74-90 Auburn Street, Portland, ME

Auburn Street Mobil

RE: 2,670 sq. ft. Convenience Store, 74-90 Auburn Street
ID #2005-0214, CBL #375-A-026

After review of the submittal for the proposed building located at 74-90 Auburn Street, the following comments have been generated:

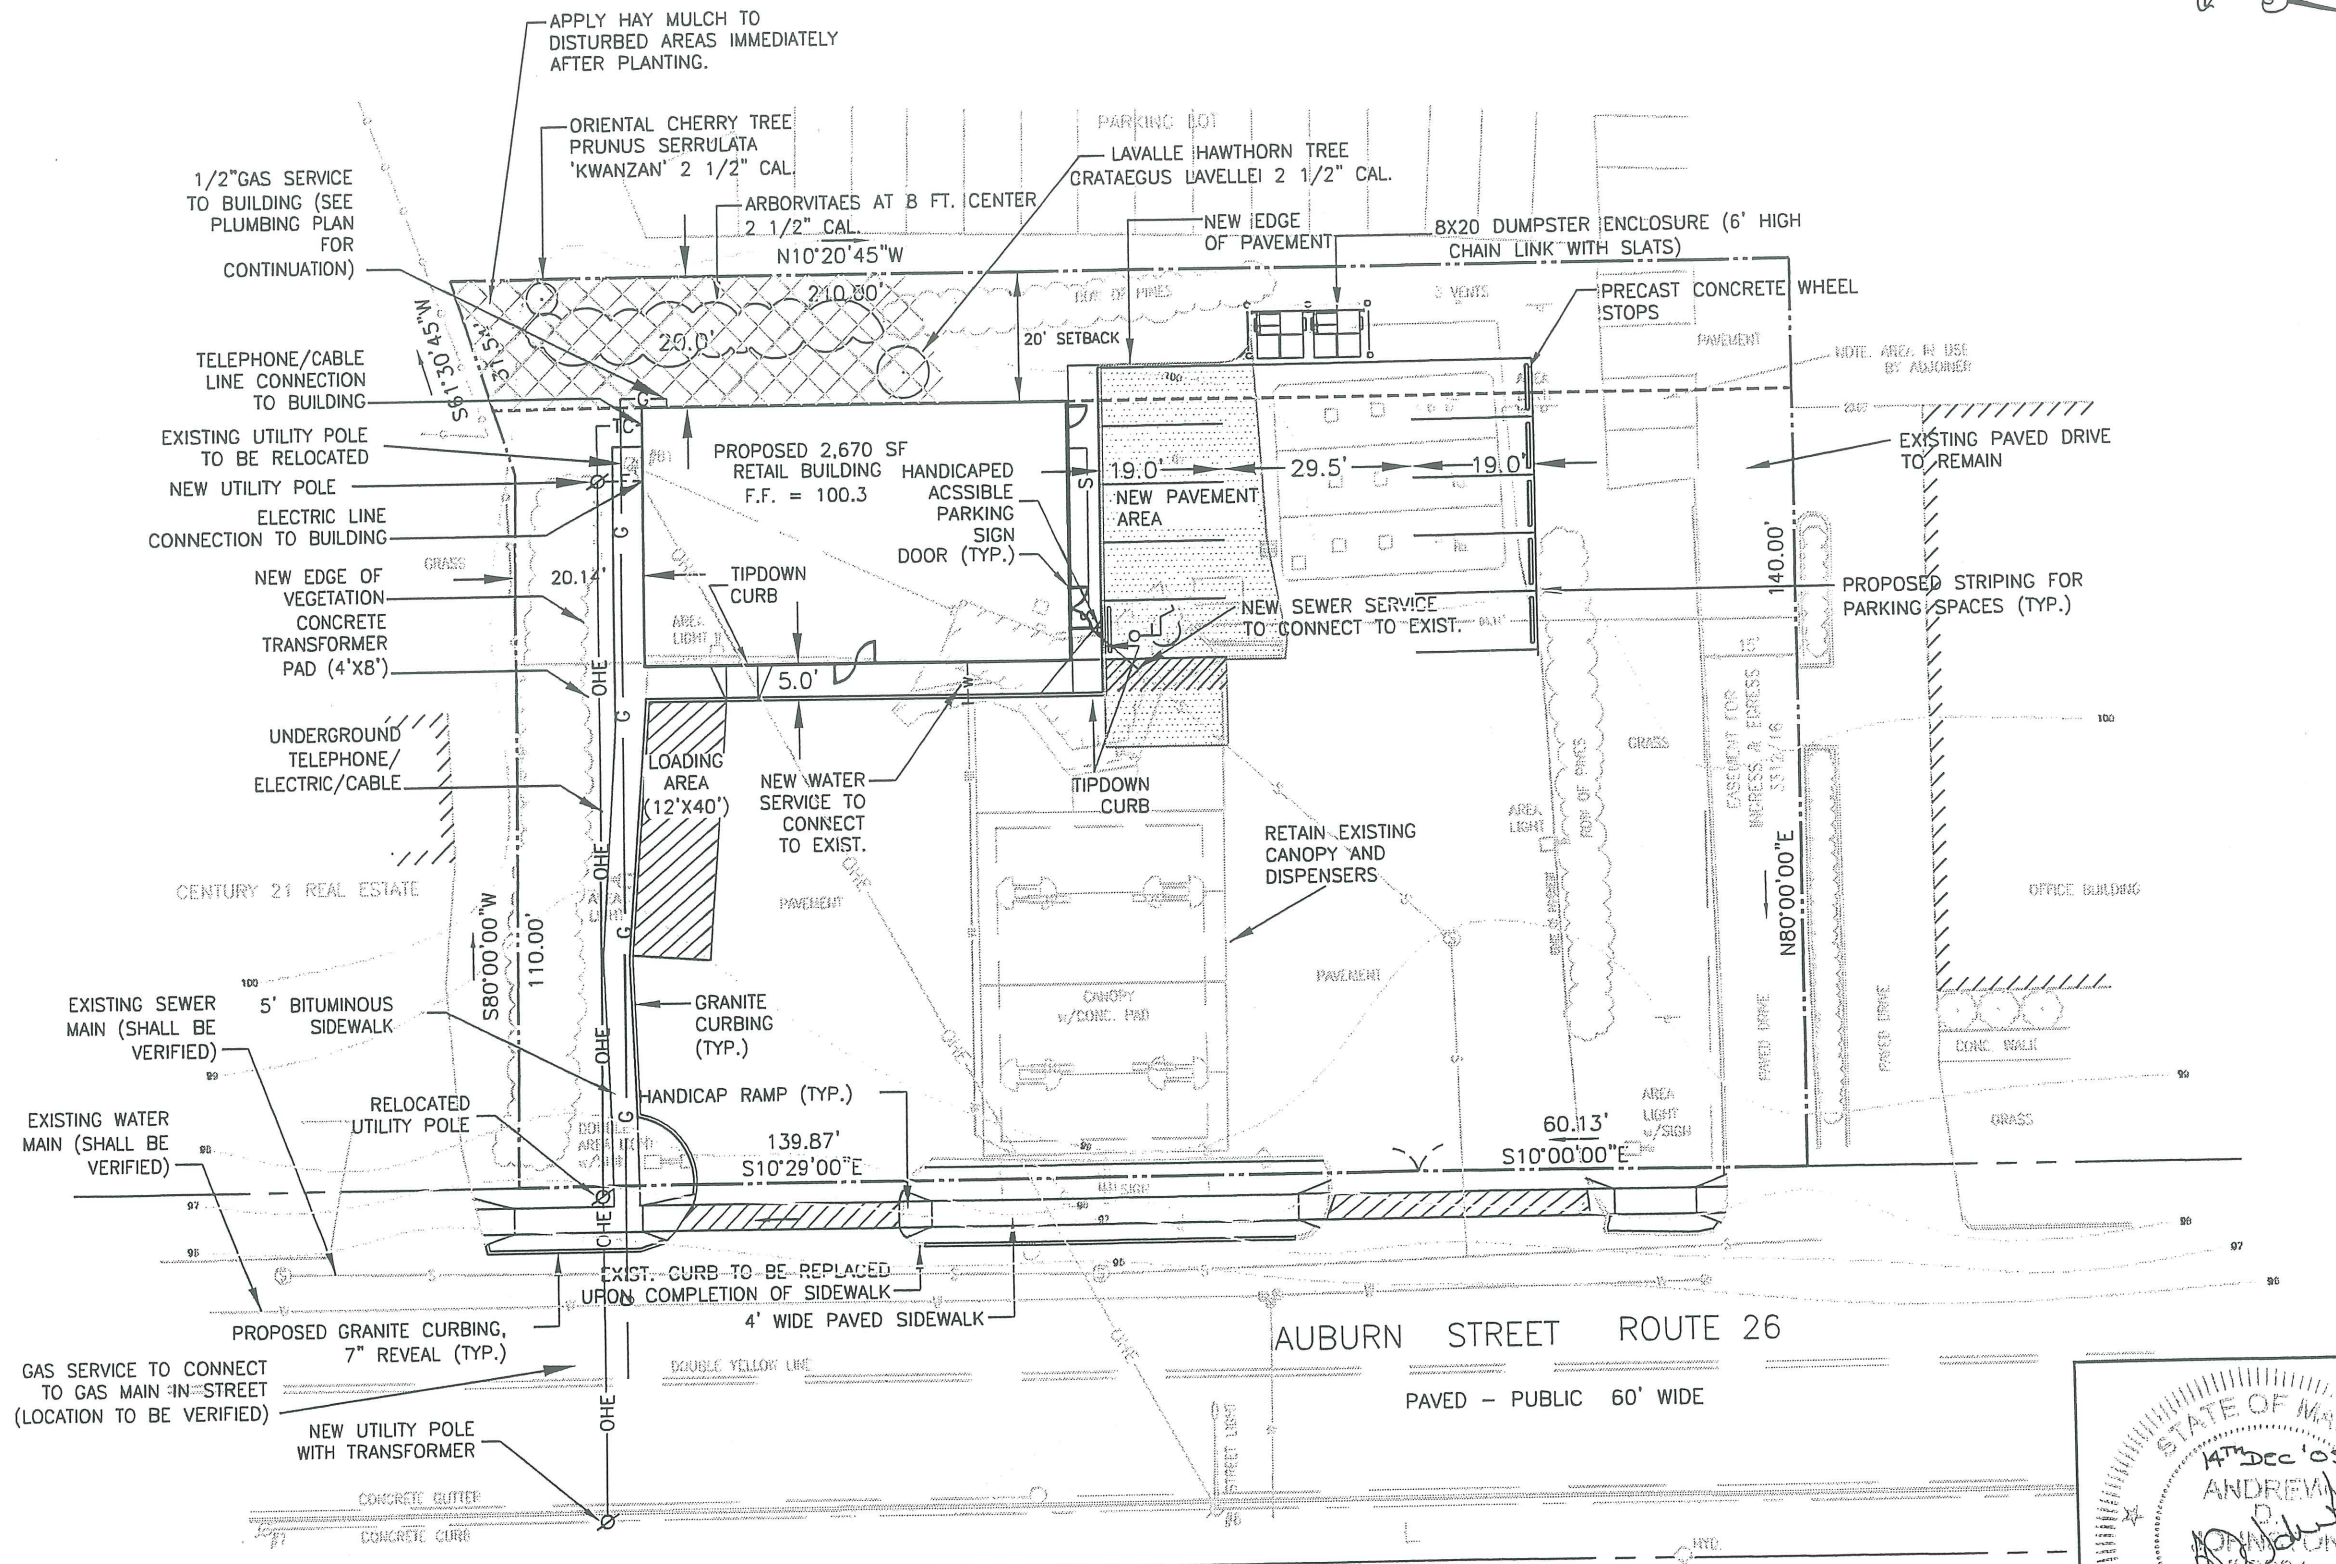
4. The proposed sidewalk on the northerly side of the site is shown half within the right-of-way and half on the applicant's property. What is the reasoning behind this? The sidewalk should be located within the right-of-way, however, if there is a reason that it can't be located within the right-of-way, then a pedestrian easement will be necessary.
